Town & Country Planning Act 1990 (as amended) s211 Notice

Prior Notification of Work to Tree(s) in a Conservation Area

Development: T1- red oak- prune all lateral branches overhanging back to boundary line.
T2- Maple- prune all lateral branches overhanging back to boundary line.
T3- Maple- prune all lateral branches overhanging back to boundary line.
T4- Red oak- prune all lateral branches by a maximum of 2 meters.
Location: Shoulders Main Road Yapton BN18 0EU

Sketch plan

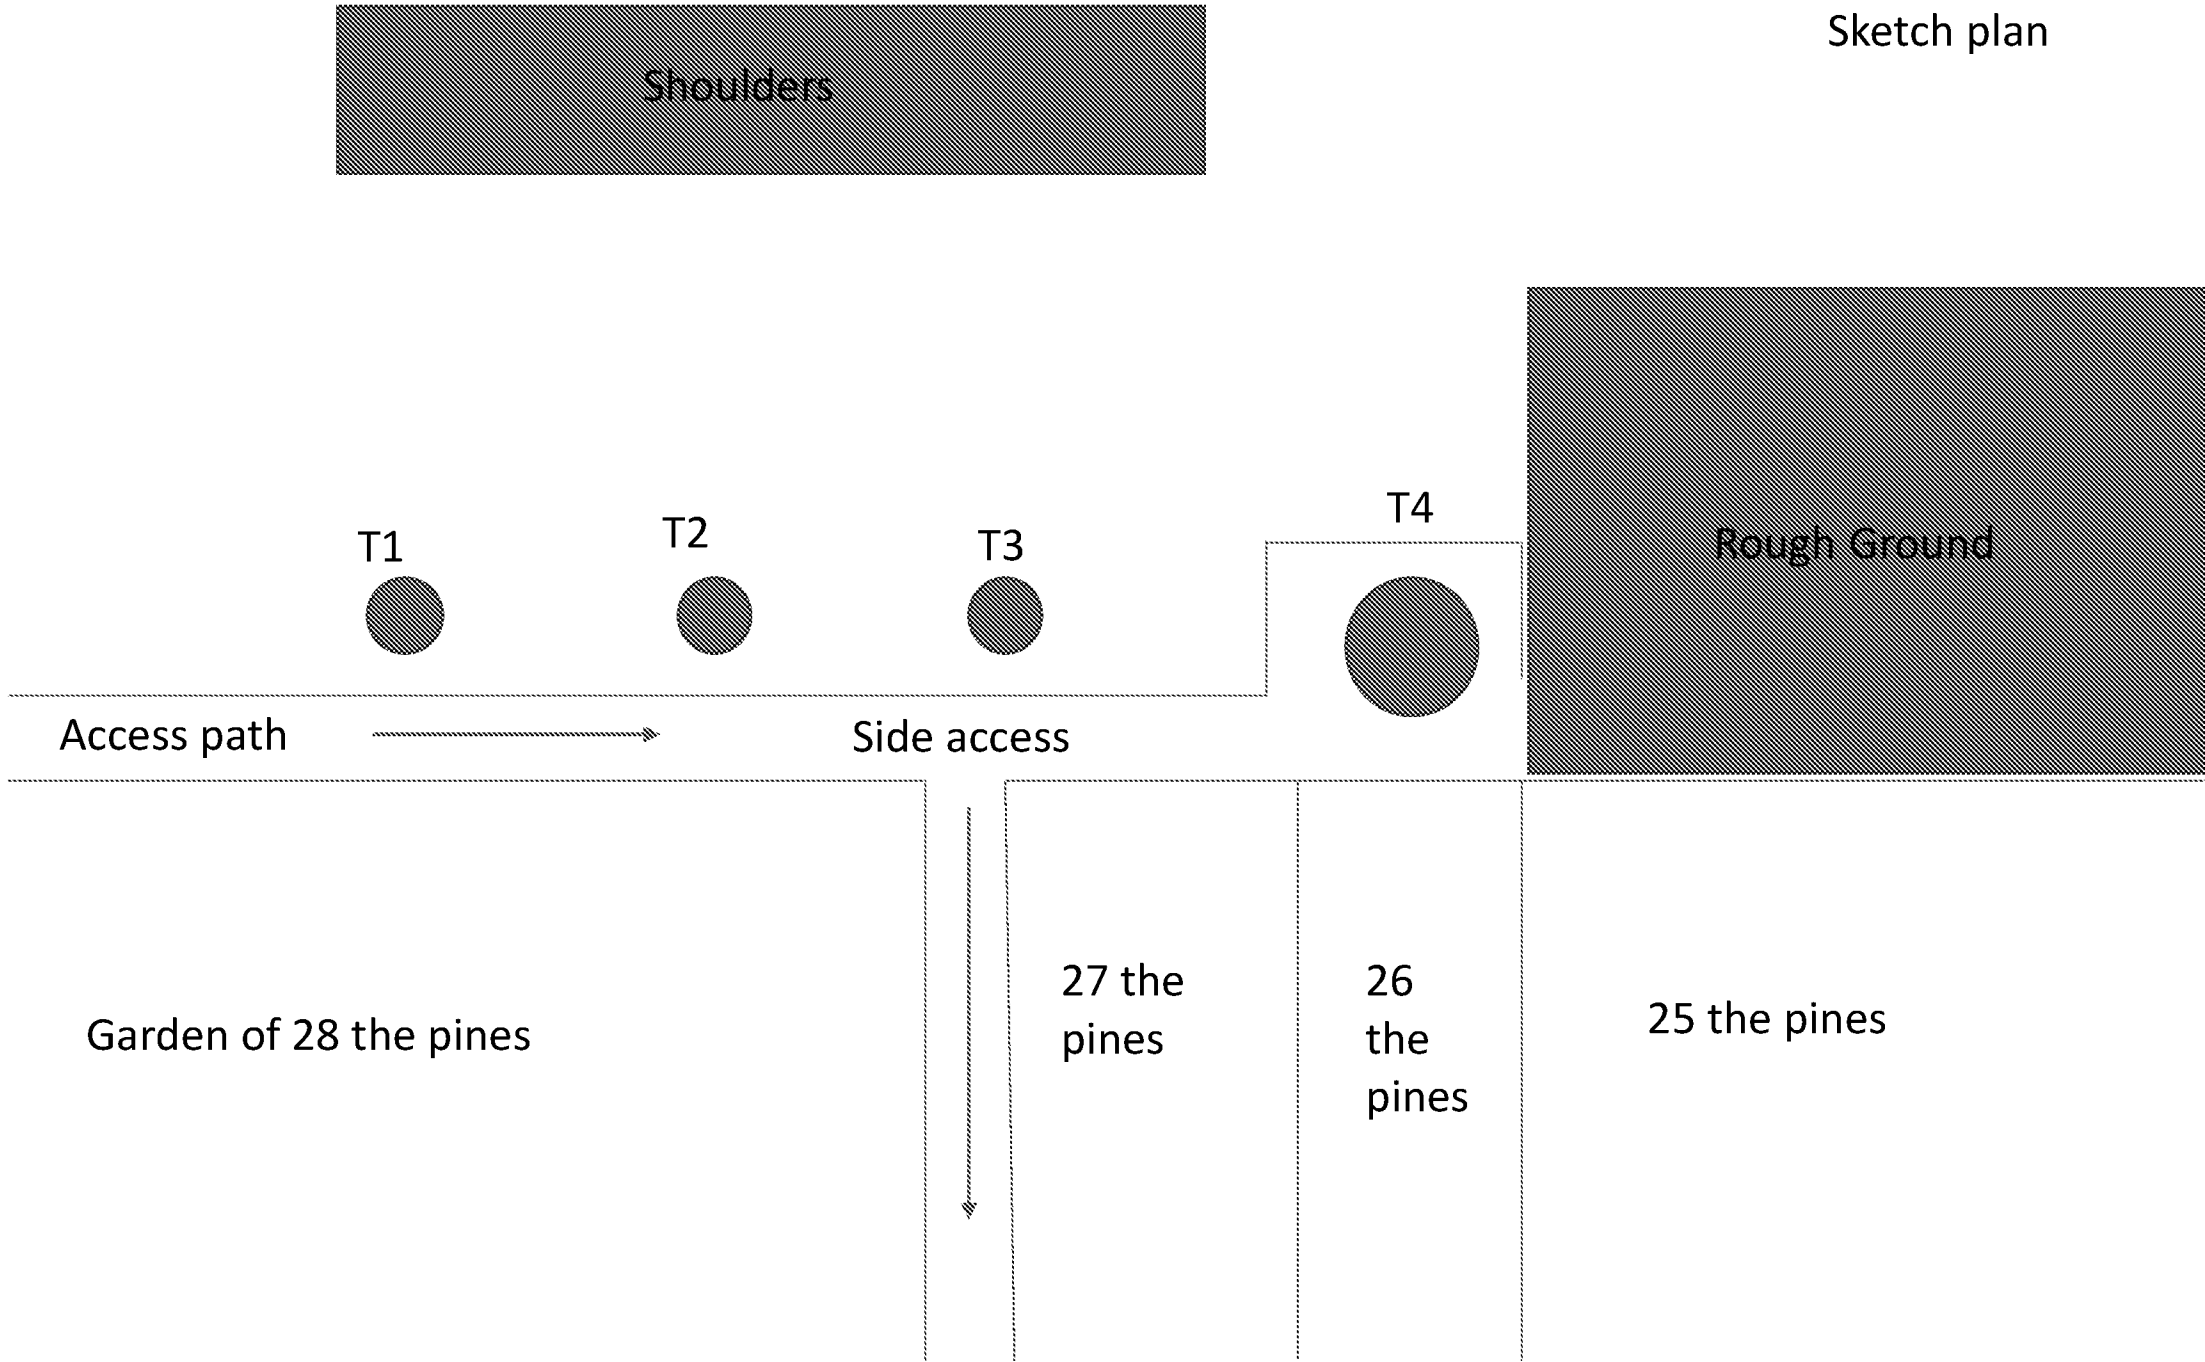
Please provide the measurements to be removed from T1, T2 and T3.

Please provide the measurements of laterals after pruning for T1, T2, T3 and T4
